Your Ref: A/168/21/PL

Date 18th August 2021

RE: Land South Of Littlehampton Road and East of Worthing Road Angmering BN12 6PN

Thank you for your correspondence of the 18th of August 2021, advising me of a planning application for Erection of 76 No. dwellings, means of access, public open space, play areas, associated infrastructure & landscaping. This application is a Departure from the Development plan, is in CIL Zone 5 and is CIL Liable as new dwellings & affects a Public Right of Way at the above location, for which you seek advice from a crime prevention viewpoint.

Figure 2: Current illustrative proposals for the site (June 2021).

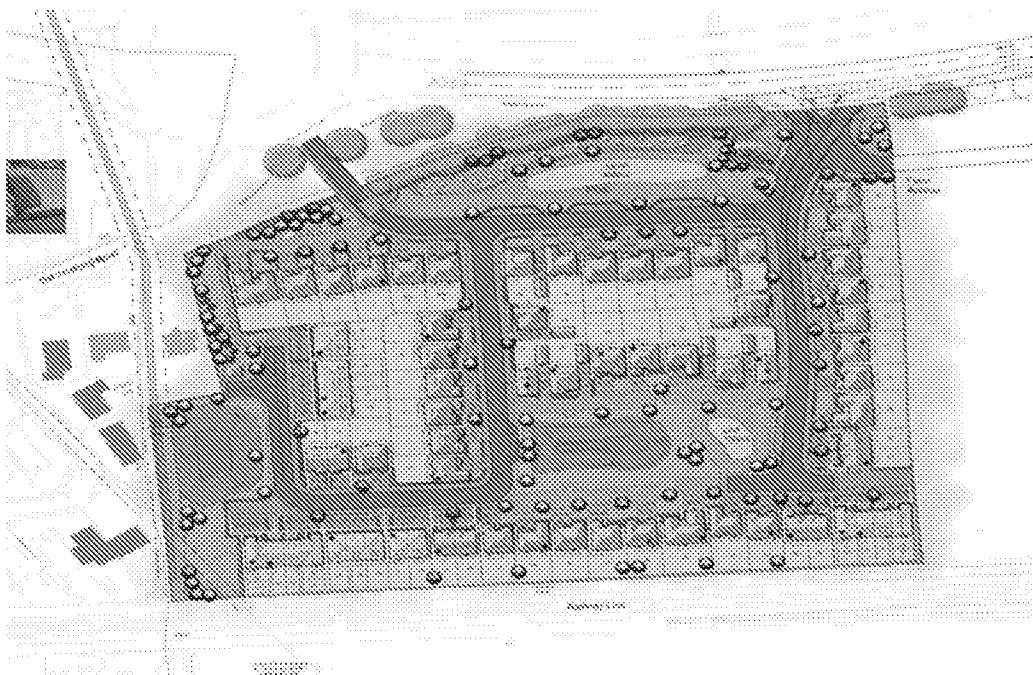
The development in the main has outward facing dwellings with back to back gardens which has created a good active frontage with the streets and the public areas being overlooked. In the main, provision has been made for car parking within the curtilage of the dwellings, with the addition of some garages and some on-street visitor bays. Where communal parking occurs it is important that they must be within view of an active room within the property. An active room is where there is direct and visual connection between the room and the street or the car parking area. Such visual connections can be expected from rooms such as kitchens and living rooms, but not from bedrooms and bathrooms.

With regards to footpath design within the development I ask that these conform to the requirements within the SBD Homes 2019 Version 2 document Chapter 8 paragraphs 8.8 - 8.12.

I note the provision of 2 play areas in the form of a LEAP and a LAP. Areas of play should be situated in an environment that is stimulating and safe for all children, be overlooked with good natural surveillance to ensure the safety of users and the protection of equipment, which can be vulnerable to misuse. They should be designed to allow natural surveillance from nearby dwellings with safe and accessible routes for users to come and go. Boundaries between public and private space should be clearly defined and open spaces must have features which prevent unauthorised vehicular access. I would ask that both areas are surrounded with railings with self-closing gates to provide a dog free environment.

In relation to landscaping - careful selection of plant species is critical in order not to impede natural surveillance and avoid unnecessary high maintenance. Trees on appropriate route stocks can provide a more reliable means of reducing the likelihood of reducing natural surveillance. Trees may restrict the performance of street lighting or cause damage by collision with branches and should not be located within 5 metres of a light source. Account must be taken of the effects of seasonal variations. As a general recommendation where good visibility is needed shrubs should be selected to have a mature growth height no higher than 1 metre, and trees should have no foliage or lower branches below 2 metres which allows 1 metre field of view between them.

Finally, lighting throughout the development will be an important consideration and where it is implemented it should conform to the recommendations within BS 5489-1:2013.
